Ribble Valley Borough Council
Council Offices
Church Walk,
Clitheroe
Lancashire
BB7 2RA

Phone: 0300 123 6780
Email: developeras@lancashire.gov.uk
Your ref: 3/2026/0488
Our ref: 3/2026/0488/HDC/KW
Date: 14 August 2026

Location: Land to the rear of The Nook Snodworth Road Langho BB6 8DR
Proposal: Erection of 6 dwellings with associated access and landscaping.
Grid Ref: 370744 433584

Z:\projects\4889 York Road, Langho\CAD\EDDISONS DRAWINGS\4889-F02 Rev B (Proposed Site Access).dwg

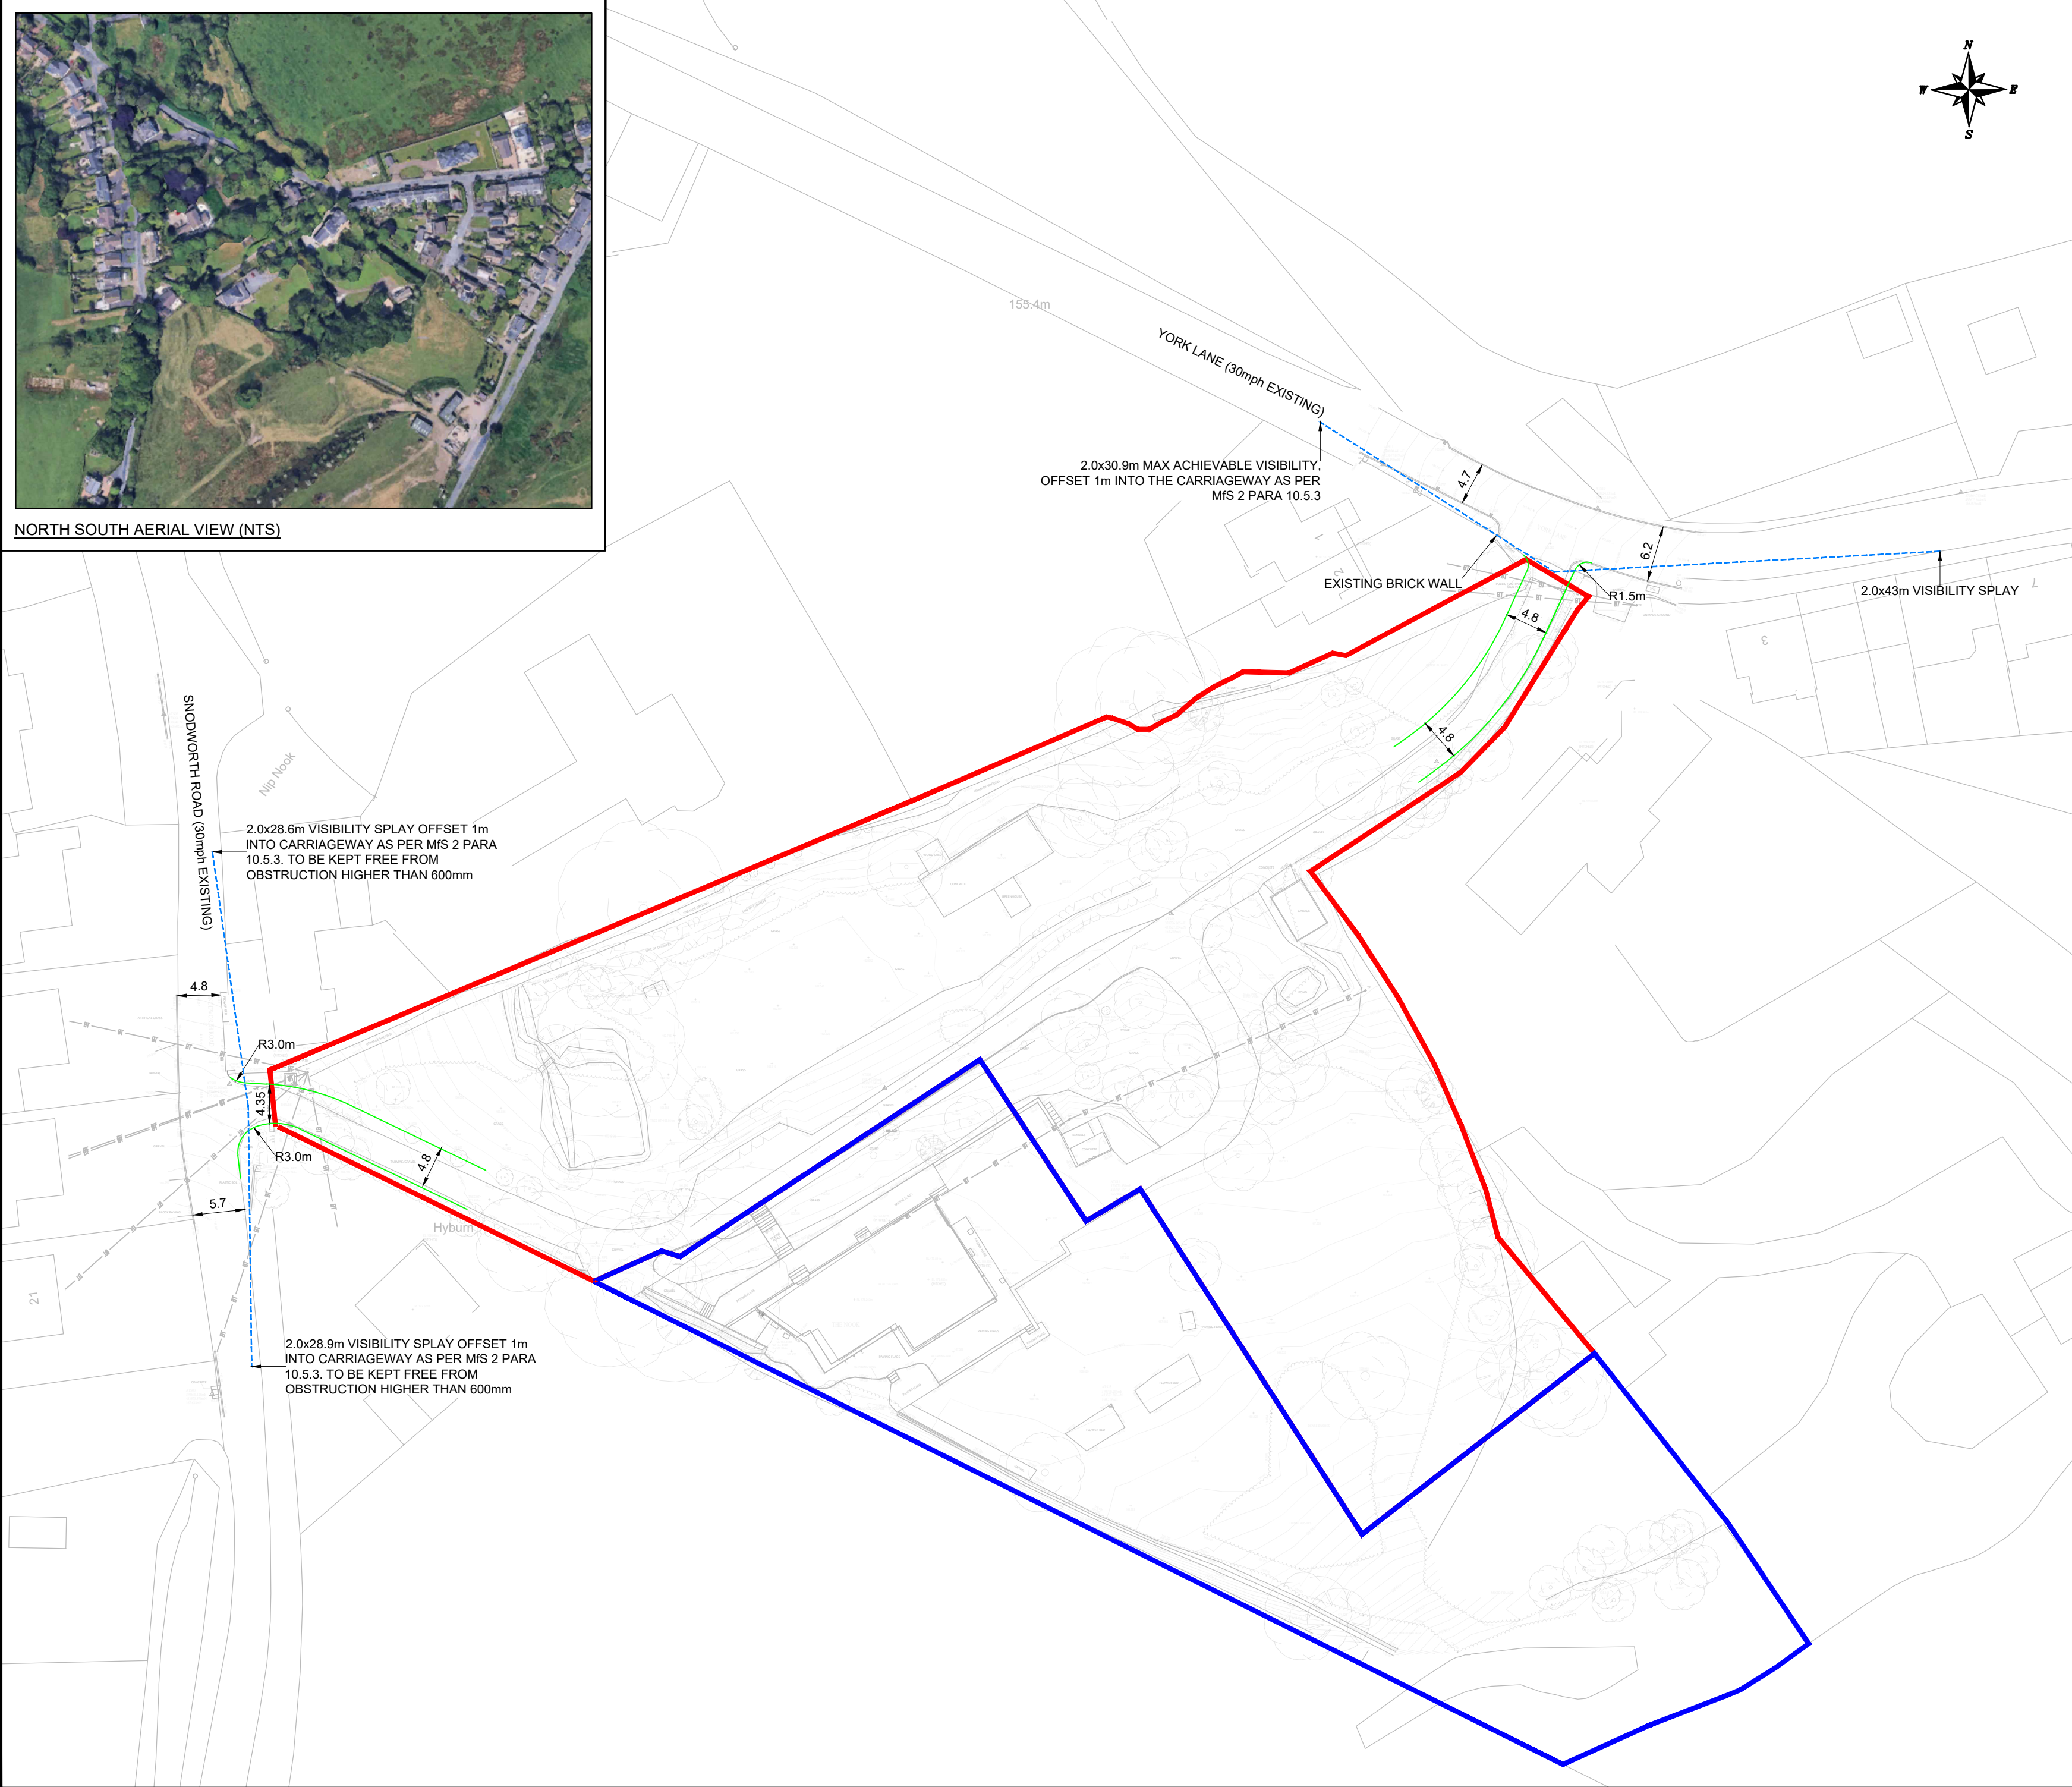
However, a review of the visibility splays shown on drawing 4889-F02, Revision A shows that the access onto Snodworth Road can provide visibility of 28.6 metres to the North and South 28.9 metres to the South. Splays in both directions have also been off set by a meter in aim to achieve the longer distance. The splays as shown result in a shortfall of 11.4 metres to the North and 11.1 metres to the South than what is required by the LHA.

Similarly, visibility splays have been shown on drawing 4889-F02, Revision A at the access onto York Lane. The drawing shows that visibility to the East is shown for 25.9 meters and to the West visibility is shown to 26.1 meters. As mentioned above the LHA

would expect visibility splays to be provided in line with the results of the survey on York Lane which 35 metres in both directions. Whilst visibility to the East has a short fall of 9.1 meters and a short fall of 8.9 meters to the West.

On site observations found that both access points rely on third-party land in order to achieve the splays as detailed above; as such, in reality the achievable visibility splays are likely to be much lower than is stated within the drawings as the applicant cannot control obstructions which fall within neighbouring properties. There is currently walls and vegetation within third-party land that obstruct the view of users on the network, meaning at both access points drivers are required to edge out into the carriageway in order to observe users already on the network. This poses a significant risk not only to vehicles exiting the access points but also to those on the network, including within the shared space carriageways between vehicles and pedestrians.
